February 24, 2025

**Re: Kairos Power Pond– 5102 Hawking Dr. SE  
Erosion and Sediment Control Plan  
Engineer’s Stamp Date (2/18/25) (Q16E5000D)**

Based on the information in your submittal received on 2/20/25, the above-referenced ESC Plan can't be approved for Building Permit until the following comments are addressed.

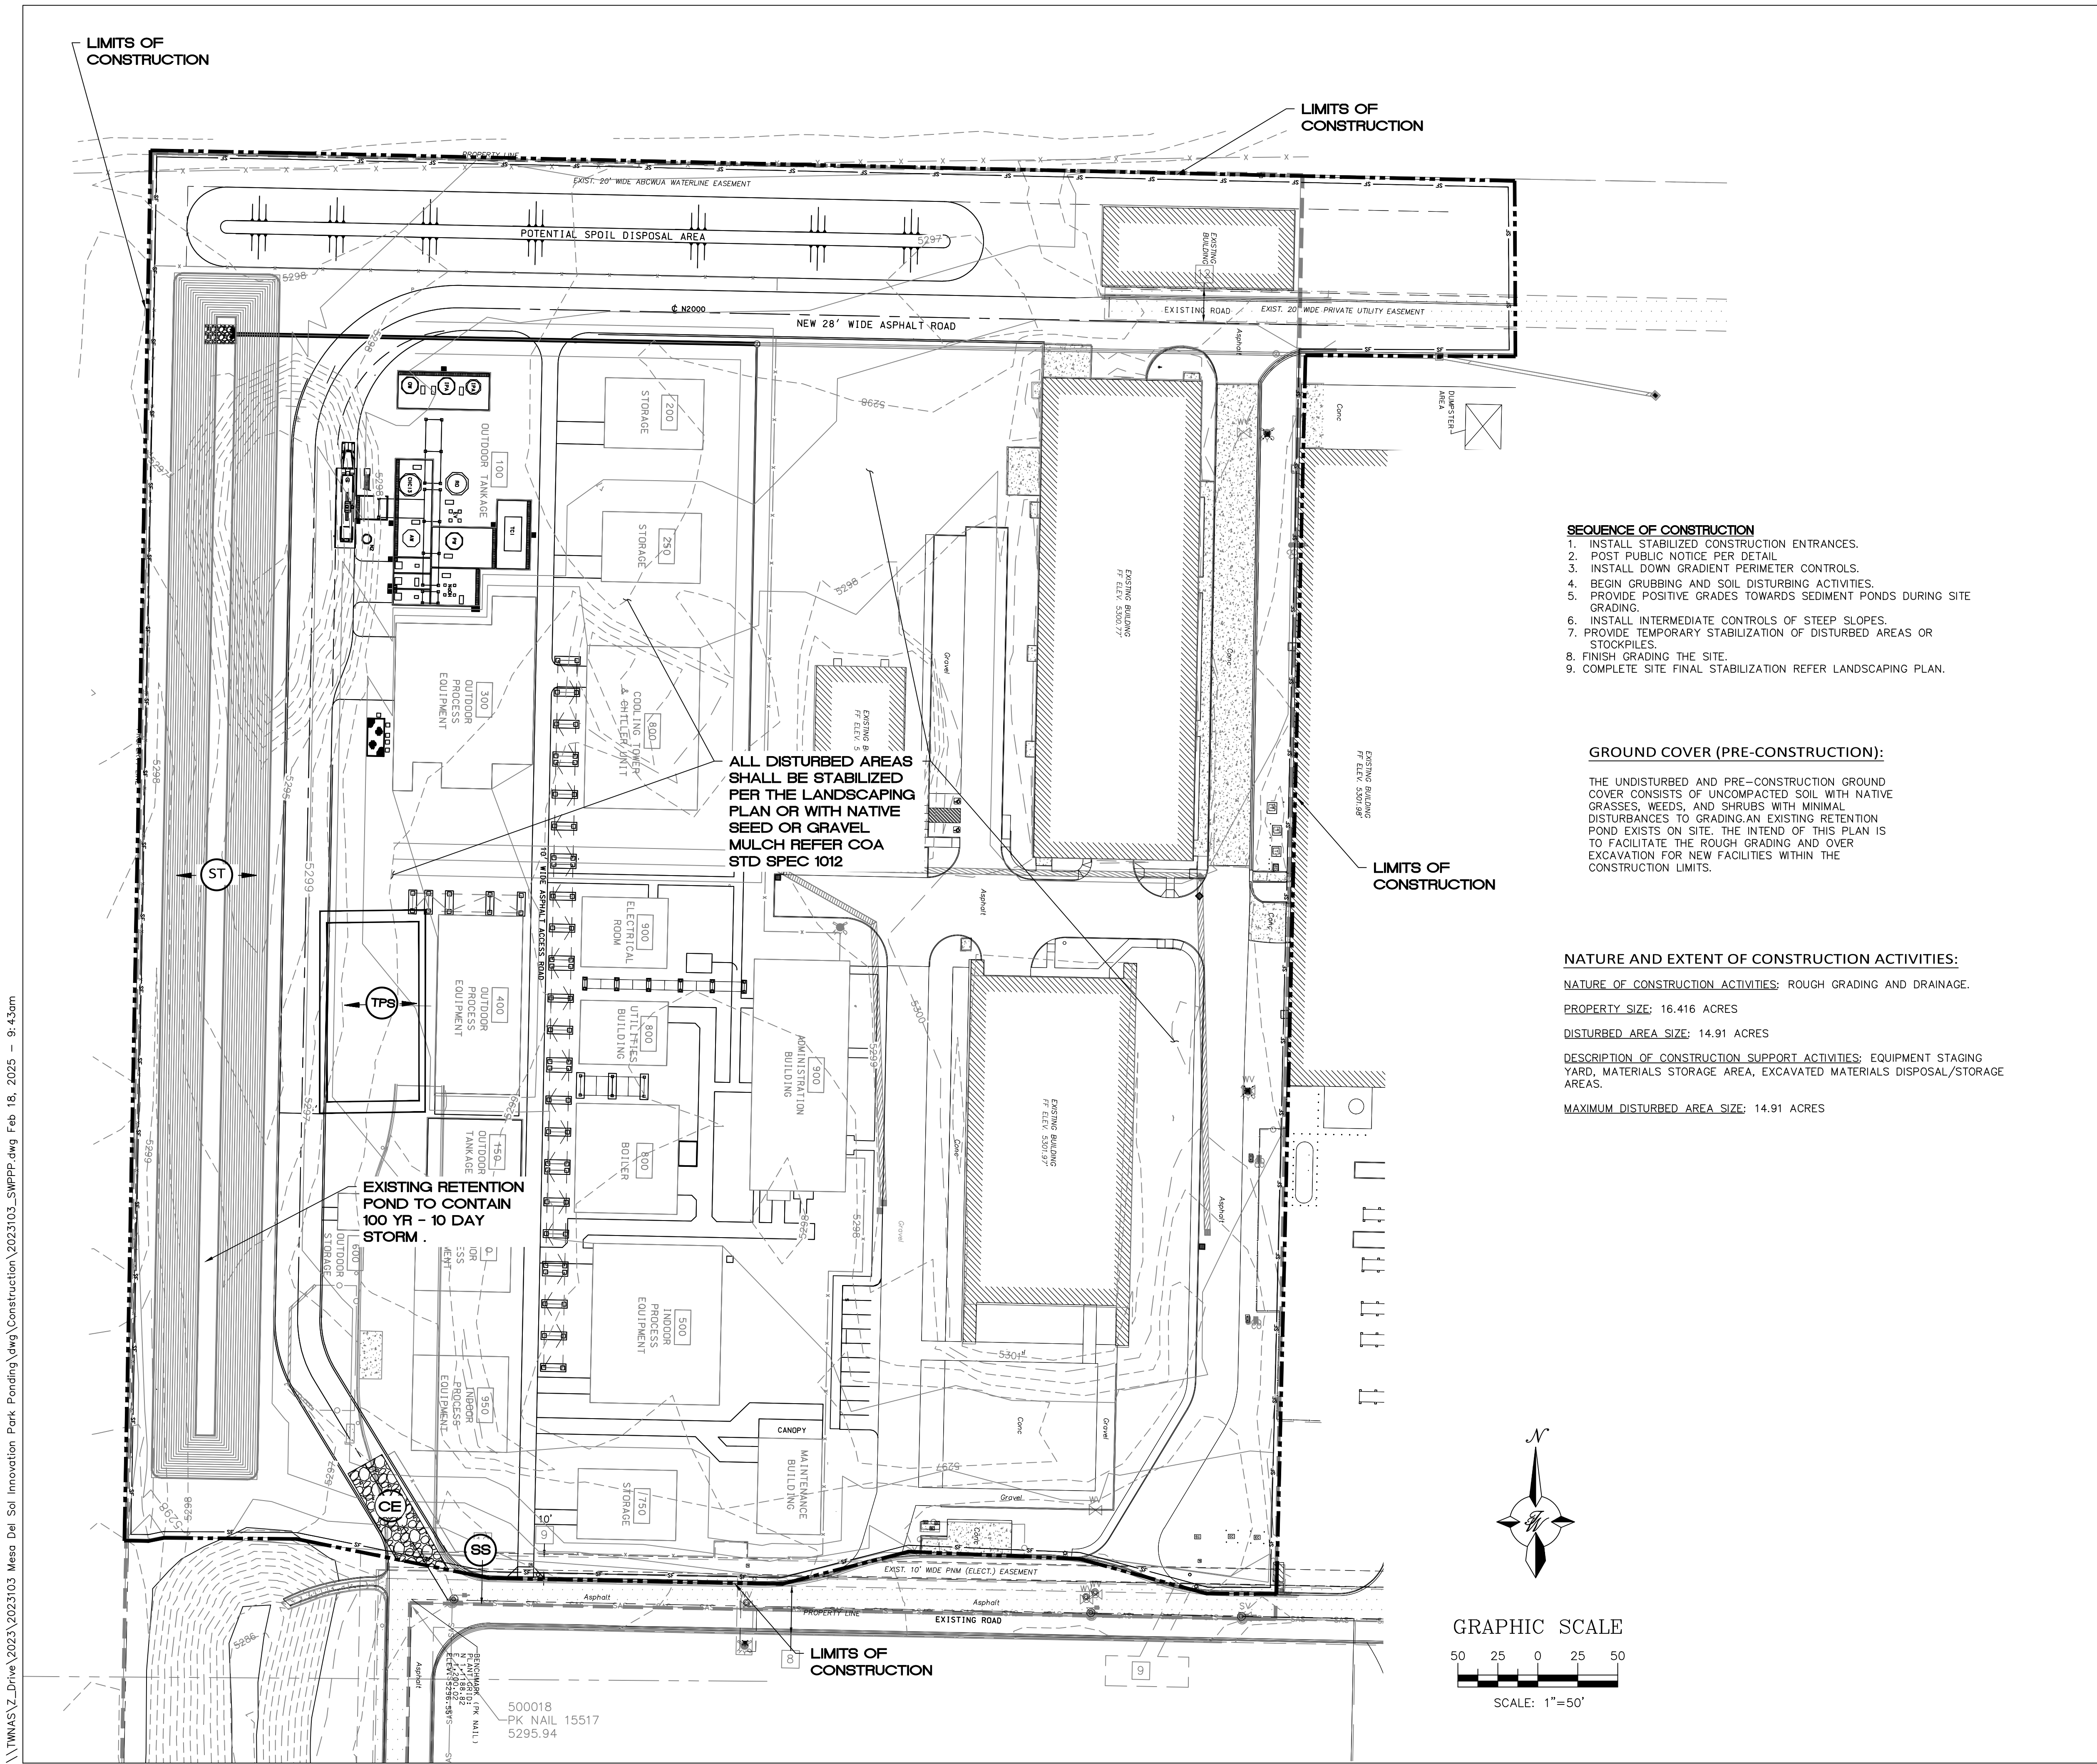
1. The existing and proposed grades are missing and inaccurate. I attached the Hydrology approval for “Grading and DFT, not for Building Permits.” It says a more detailed G&D Plan is needed for Building Permits. That more detailed G&D Plan will be the base map for a revised ESC Plan. The ESC Plan you submitted can't be approved until Hydrology approves a G&D Plan and those grades are shown on a revised ESC Plan.
2. On the phone, we discussed terminating the old NOI, NMR1004XE, and replacing it with the new NOI, NMR10069Y, for the entire area of disturbance. The resubmitted ESC Plan only needs to cover the remaining areas of disturbance, but the NOI needs to include the total area of disturbance since the project started. Also, ensure that the “Operator Point of Contact” and “Project Name” are up-to-date.

You will need to resubmit a revised NOI and ESC Plan using the same # SWQ-2025-00011 after you have a detailed G&D Plan approved by Hydrology. If you have any questions, contact me at 924-3420 or [jhughes@cabq.gov](mailto:jhughes@cabq.gov).
